M3 JUNCTION 9 NATIONALLY SIGNIFICANT INFRASTRUCTURE PROJECT

Written Summary of Oral Submissions

Issue Specific Hearings 1, 2 and 3

18 August 2023

DRAWING TITLE  
FIGURE 2.5 - THE SCHEME: TEMPORARY TRAFFIC DIVERSION ROUTES  
APFP REGULATIONS 5(2)(a)  
SHEET 4 OF 12  
DOCUMENT REFERENCE 6.2

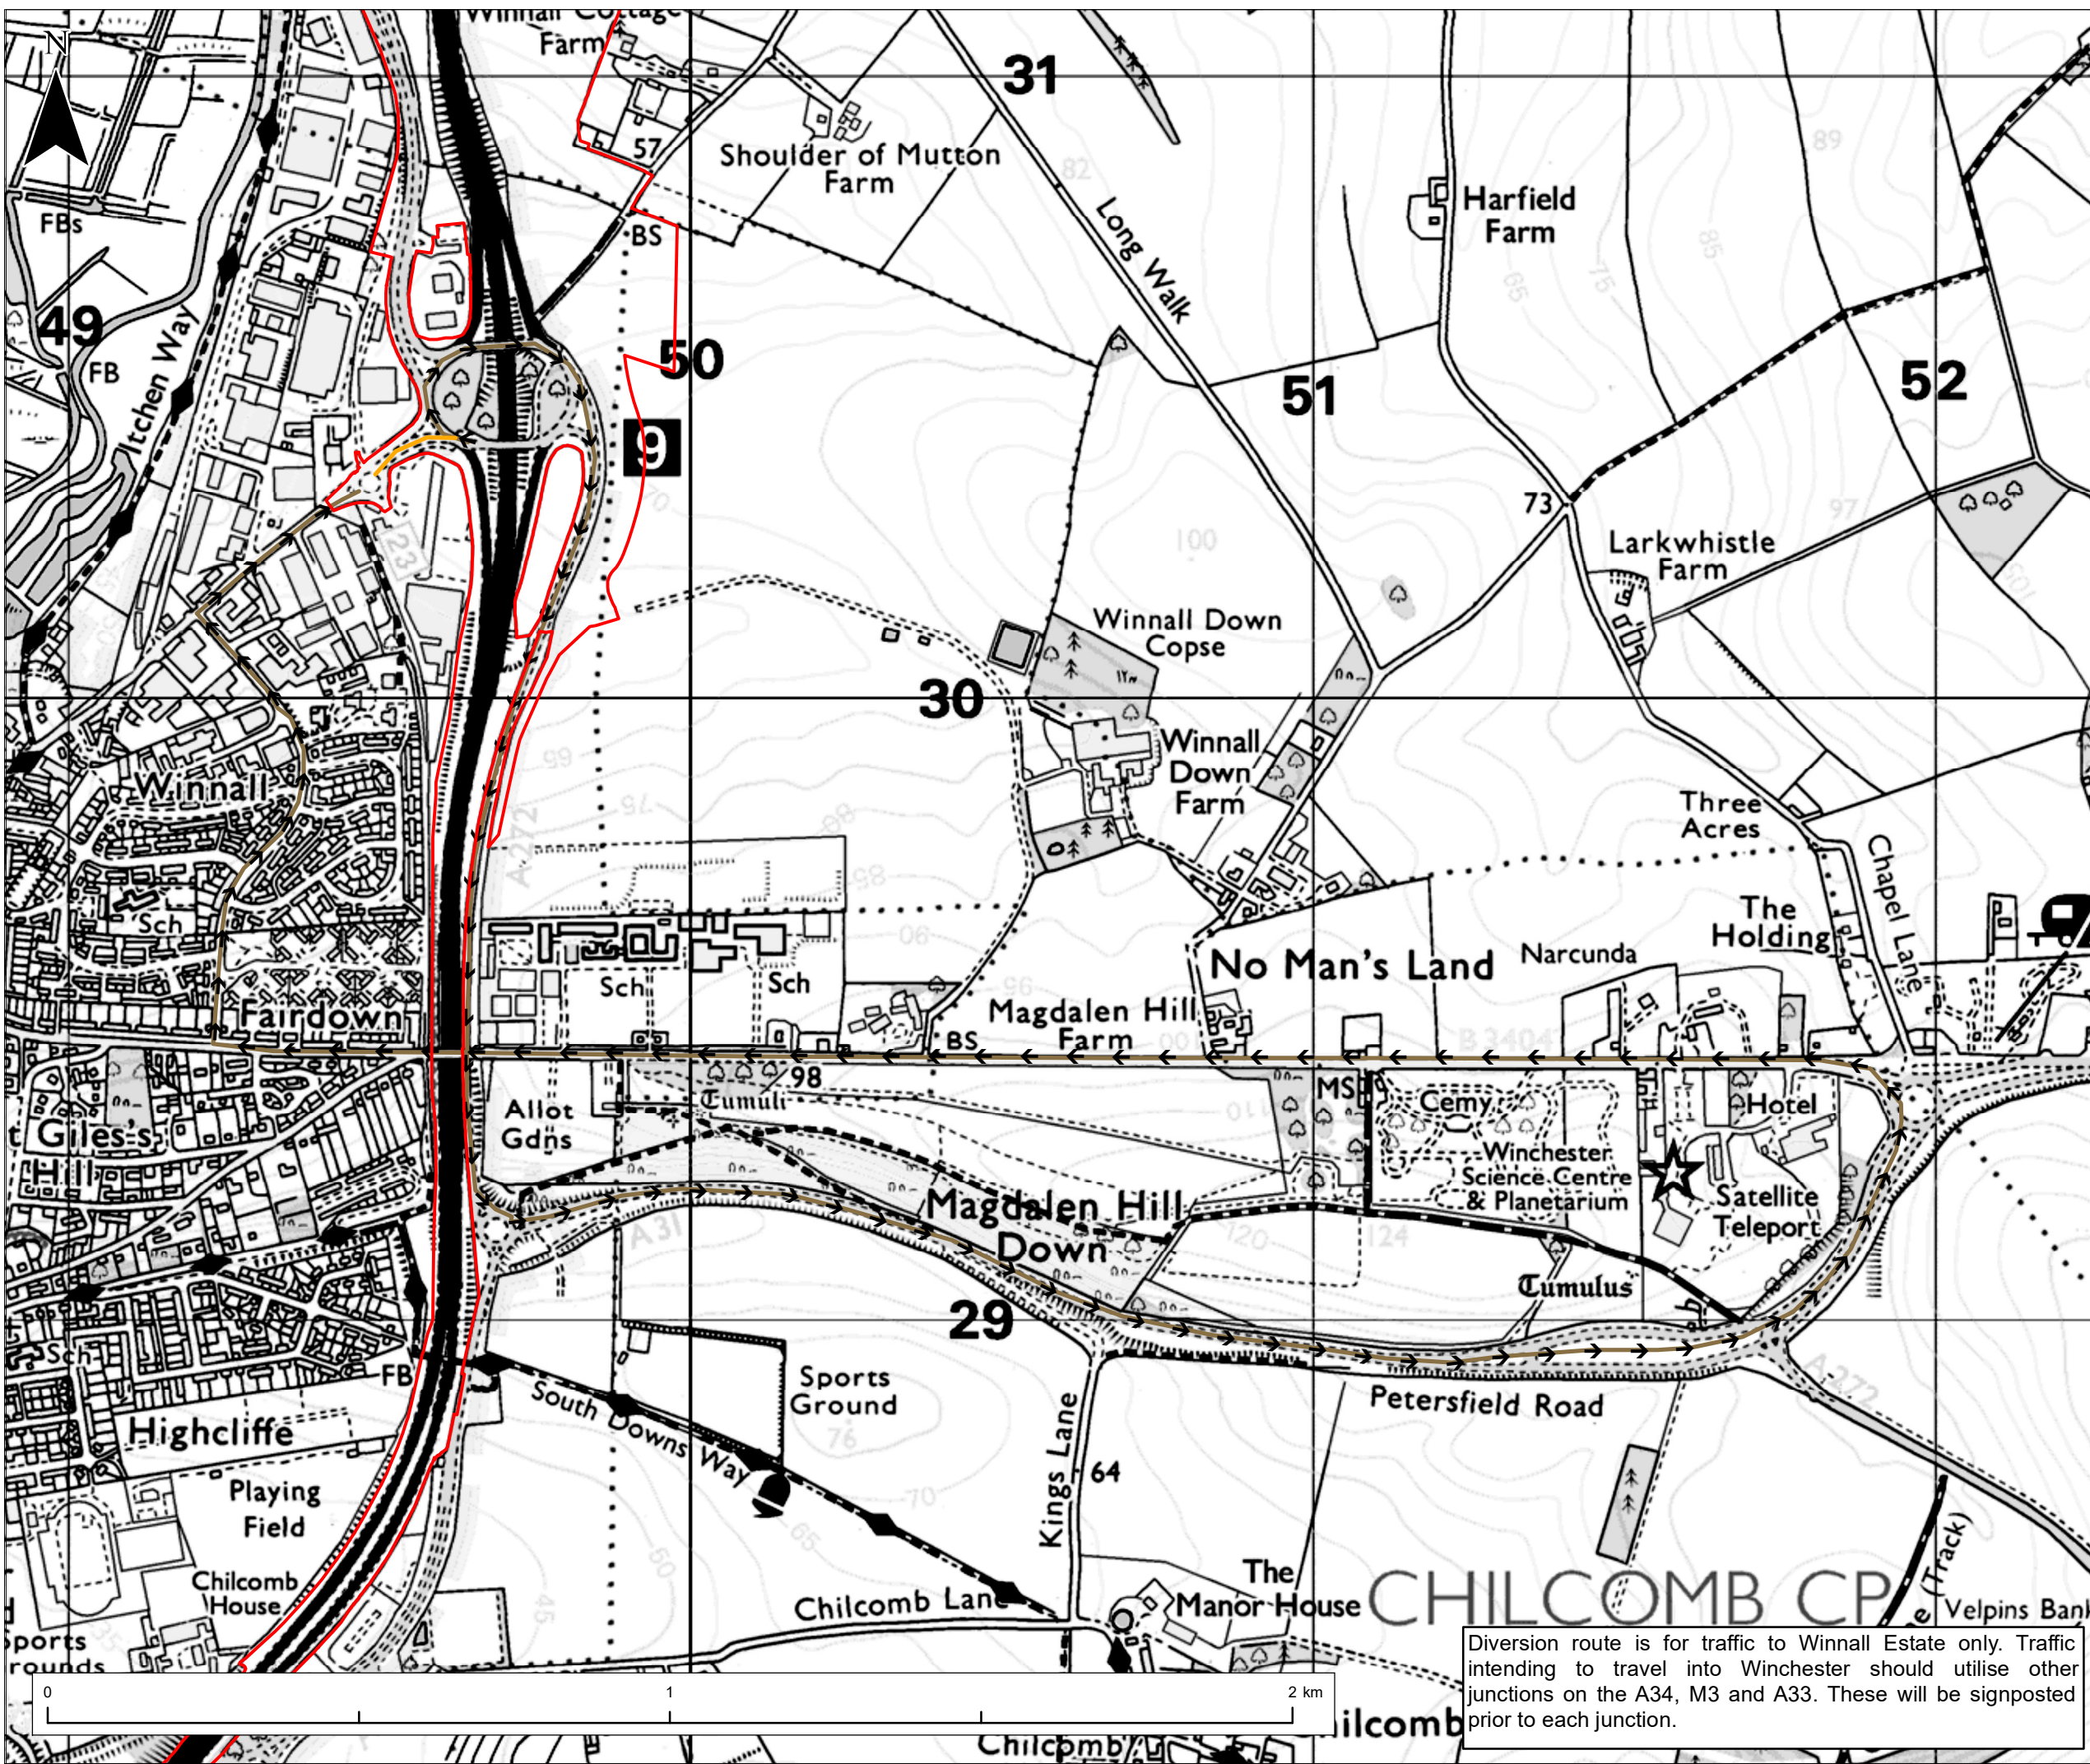
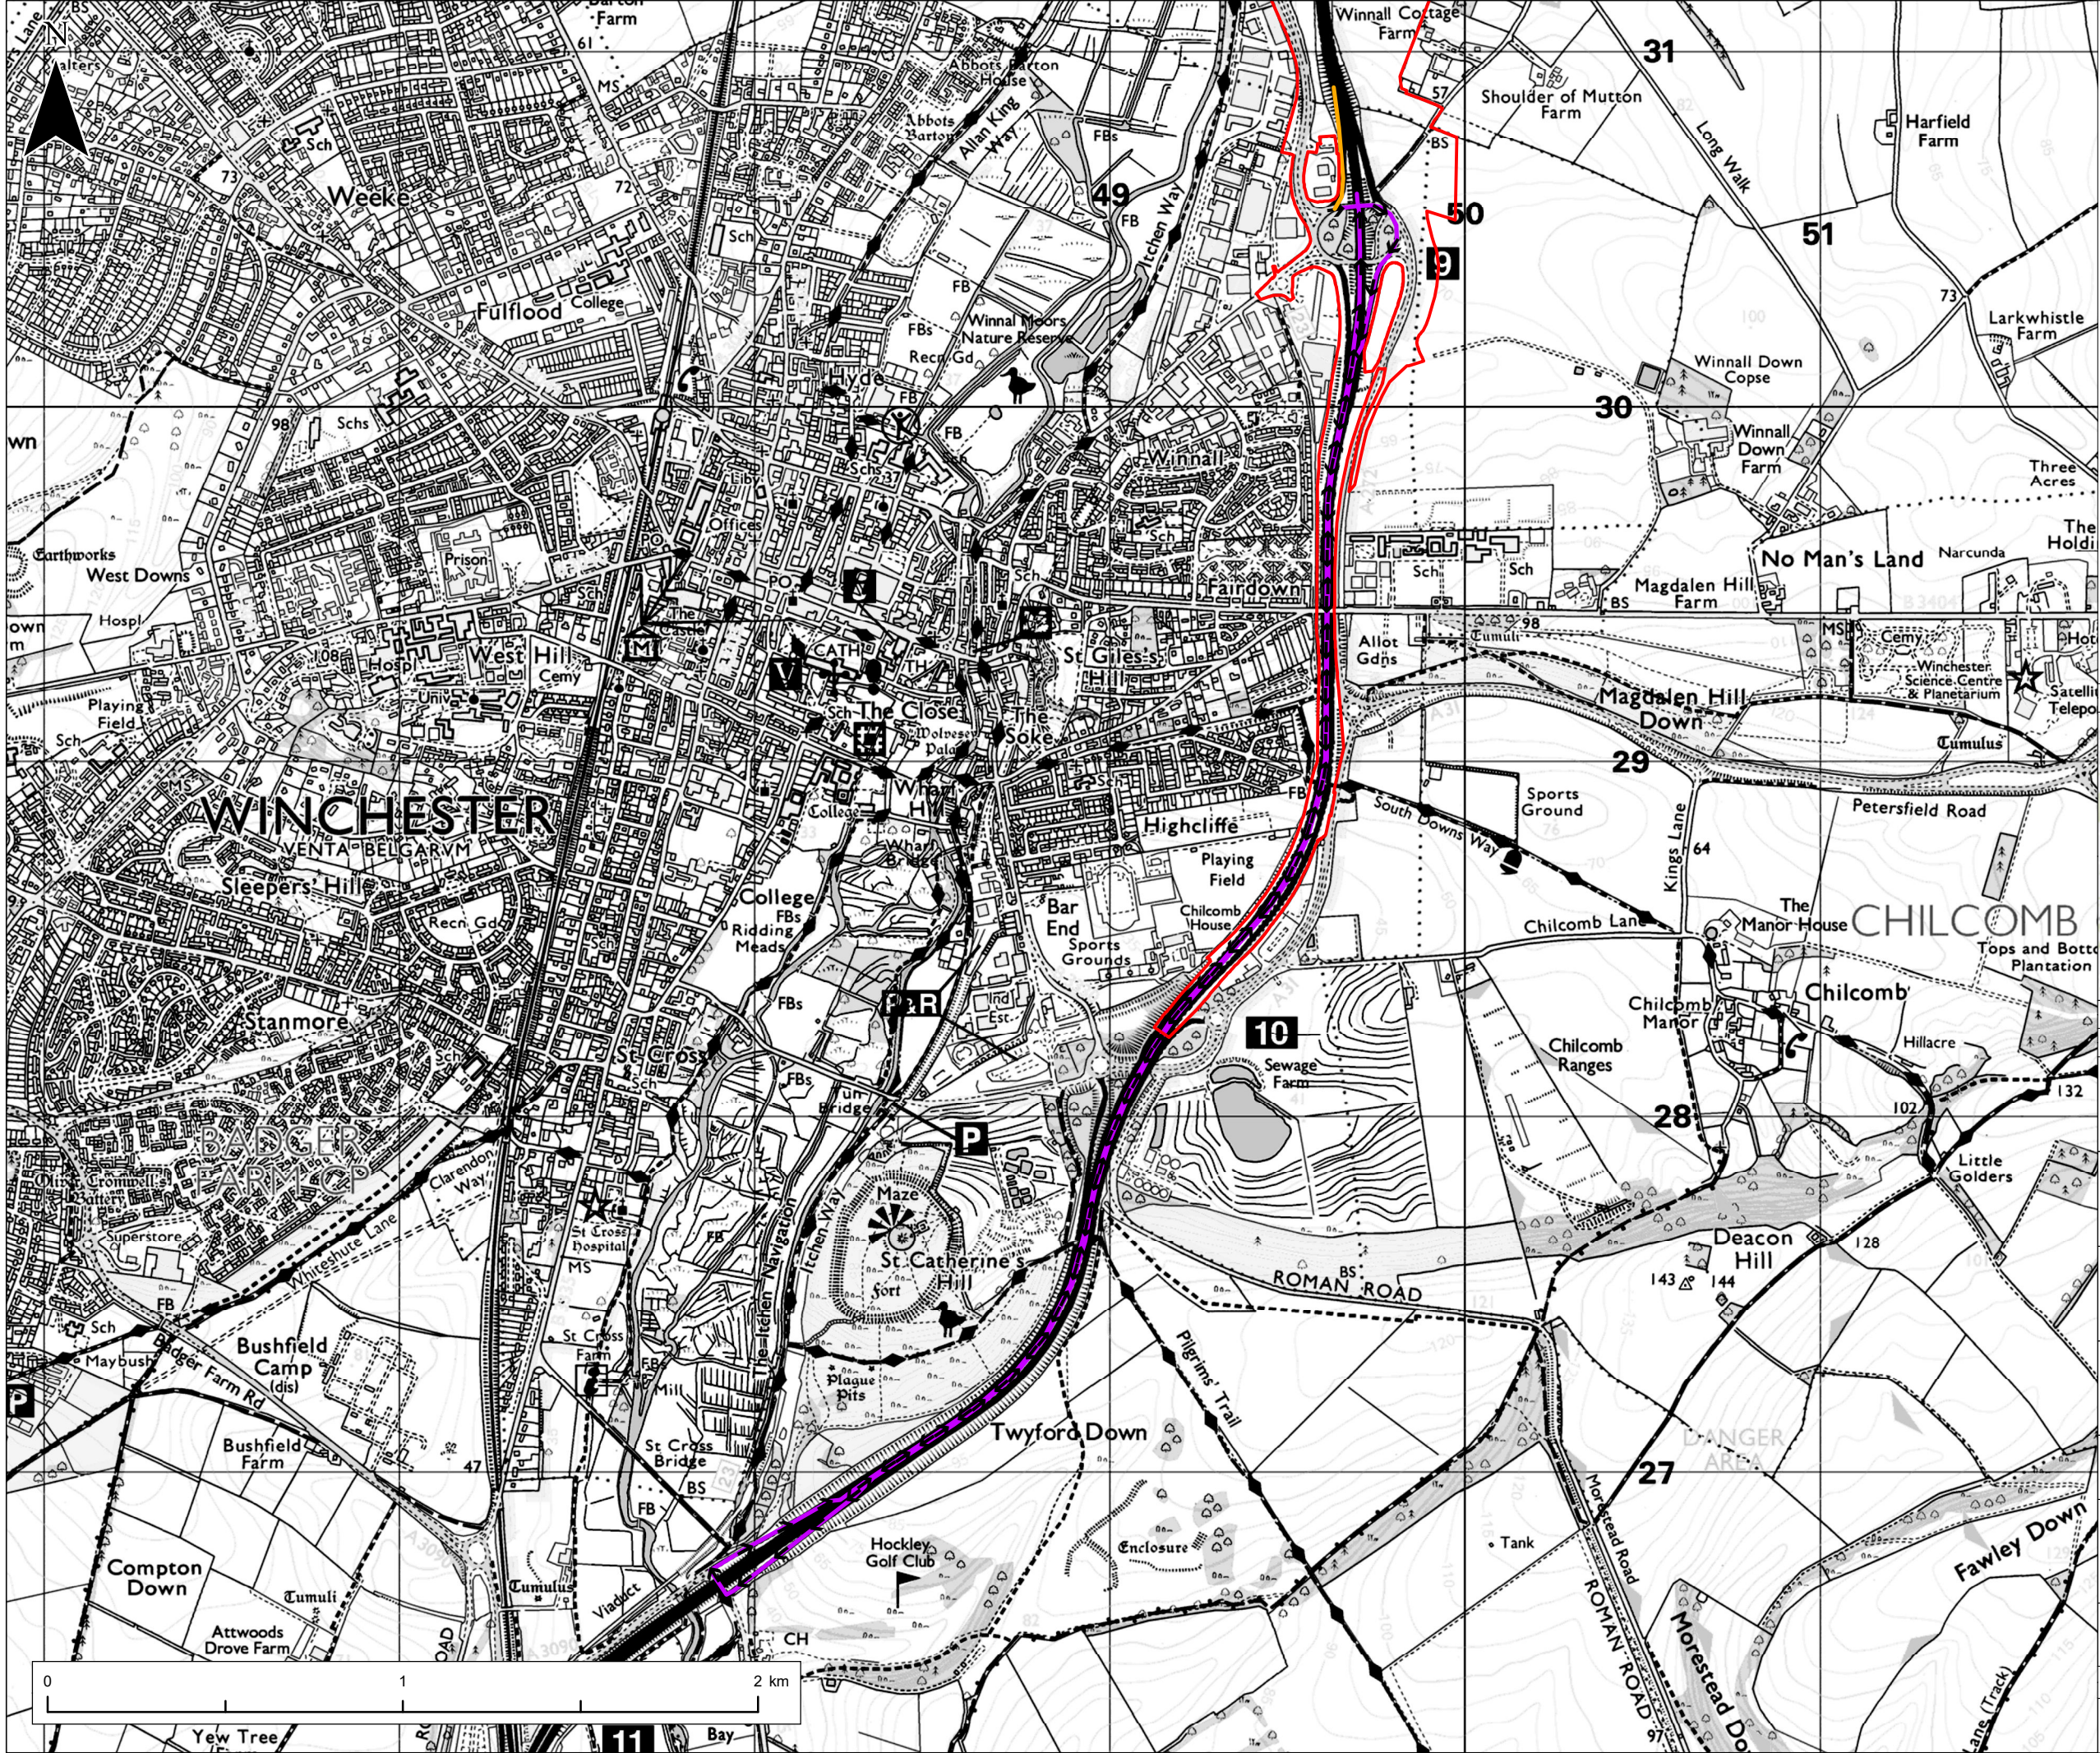
2.2.4 The City Council notes the points raised by the County Council and applicant during ISH2 which confirmed on-going discussions regarding appropriate diversion signage

(including advanced positioning, instructions not to follow sat-nav). The City Council has raised concern on the effectiveness of the diversion routes and will discuss this matter further with the County Council as Highway Authority.

2.2.5 Concerning the diversion of the Junction 9 northbound on-slip, which is required to travel southbound and then use Junction 11 for 17 months, the City Council concern relates to traffic signalling.

It is presumed that to accommodate the additional traffic using Junction 11, the signals for the M3 southbound off-slip traffic will be prioritised. This would result in increased delays for those held at traffic signals on the B3335 toward Twyford and along the Hockley Link. There is a significant pedestrian crossing on the Hockley Link serving the Itchen Way which will have to navigate the additional congestion.

The applicant confirmed at ISH2 that no traffic light alterations are proposed however this will be subject to monitoring. The City Council request clarification on the process which will be followed in the event that traffic signals are altered.
